Donna M. Palmer B. Bus, CPA, MACS.
Quality Assurance Specialist (Retired)

Re: Submission to exhibition of SSD-82709458 at 19-25 Balfour Street, Lindfield

Figure 11 - Sampled quadrats at the subject land, the 400m² quadrat shaded in blue, the larger quadrat for additional functional attributes shaded in green (Nearmap 2025). The various star icons indicate the location of some native species that occur throughout the subject site

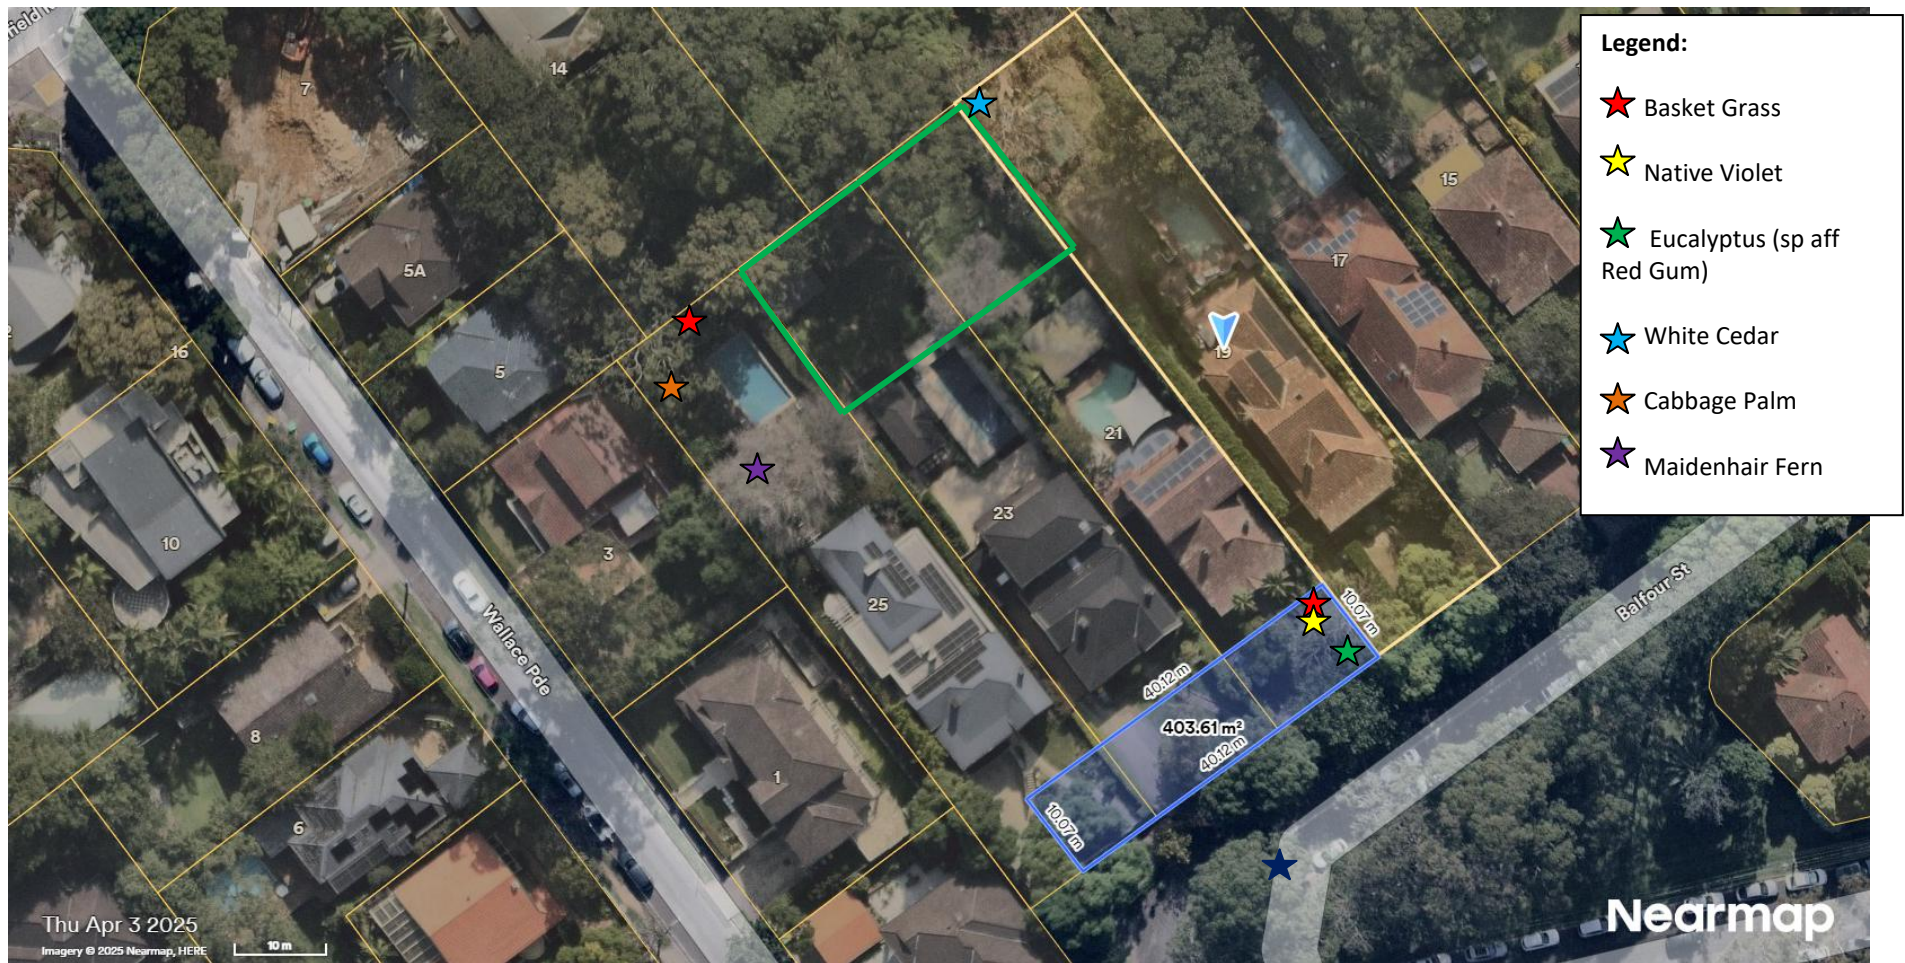
The BDAR states canopy cover now as being approx. 28%, which is less than it was prior to the illegal tree removal and suspected poisoning. The measure should be on what was there which can clearly be seen in aerial photos taken over 12 months ago. It is also unclear in this report whether calculations have been correctly determined in relation to include those elements, missing, dead or dying. For example, page 14 in Figure 11 lists the maidenhair ferns, but not the Turpentine trees on No. 25 Balfour Street.

On page 29 of the BDAR in section 3.3.1, plot 1 is not identified in Figure 11. Quantitative measures only were derived from intact vegetation. This should have included known illegal tree removals, those dead and dying and directed replacements. To not include these, continues to reward those who carry out deliberate environmental vandalism.

9
DA400
DEEP SOIL PLAN
1 : 400

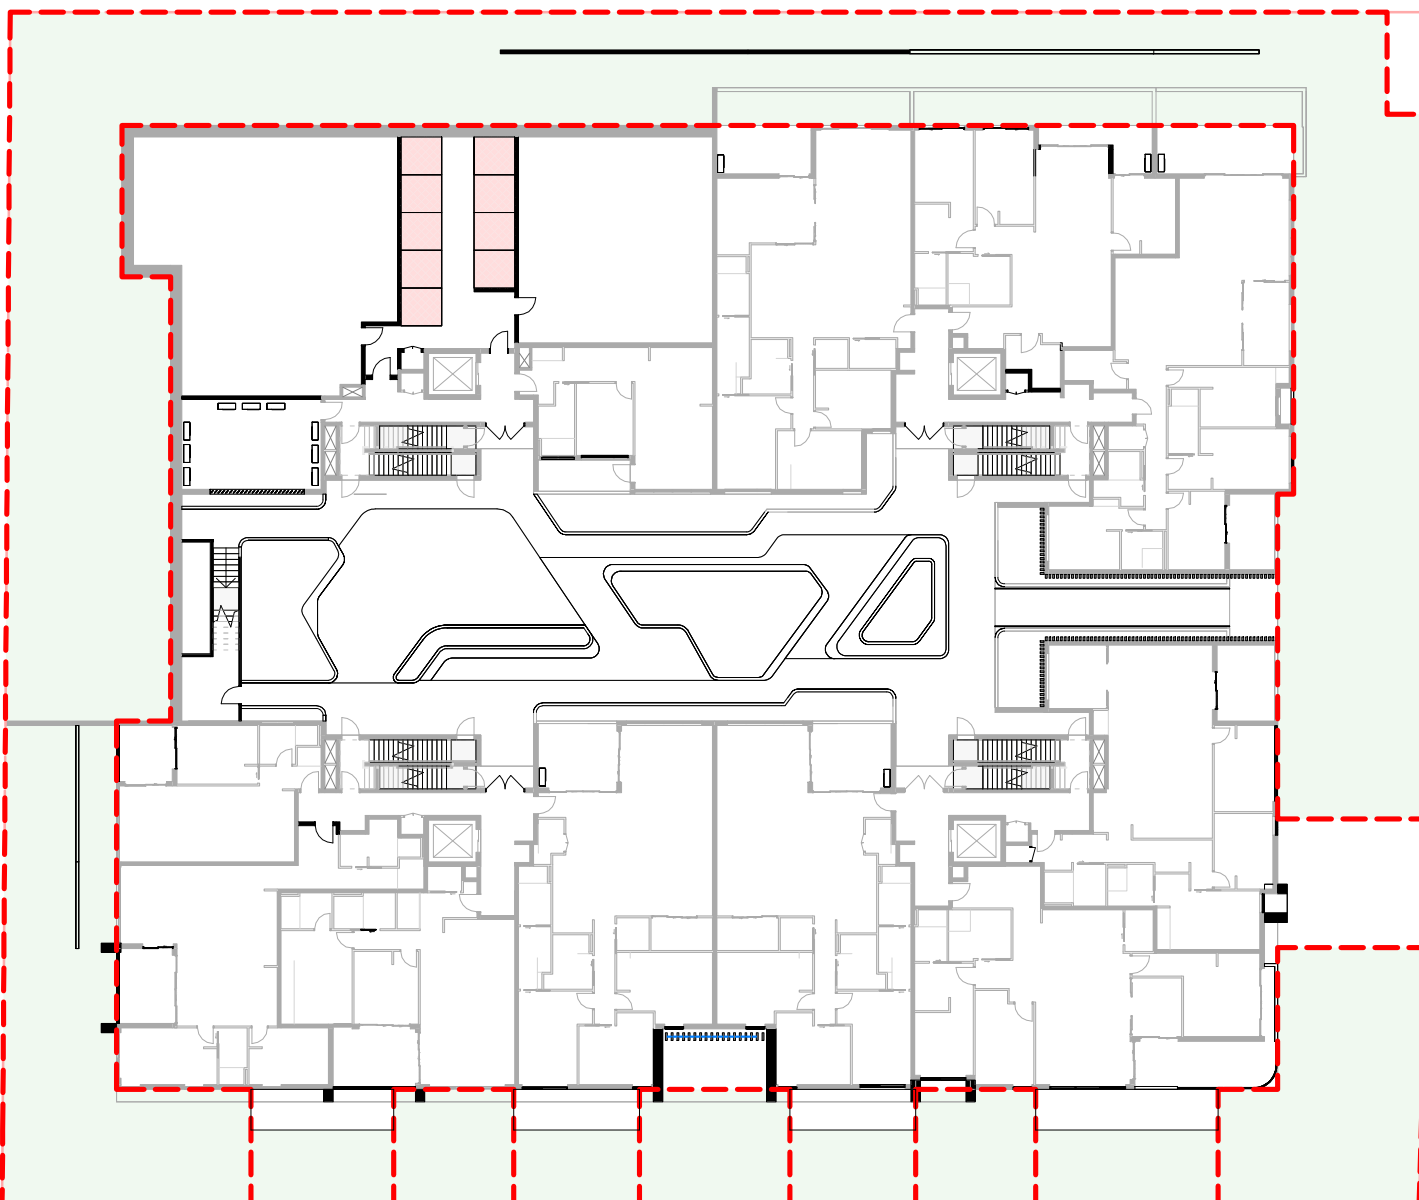
The current plan only allows for 30.4% deep soil, when Council requirements for R4 zoned land is 50%. The lodged plans mention that this requirement is not met.
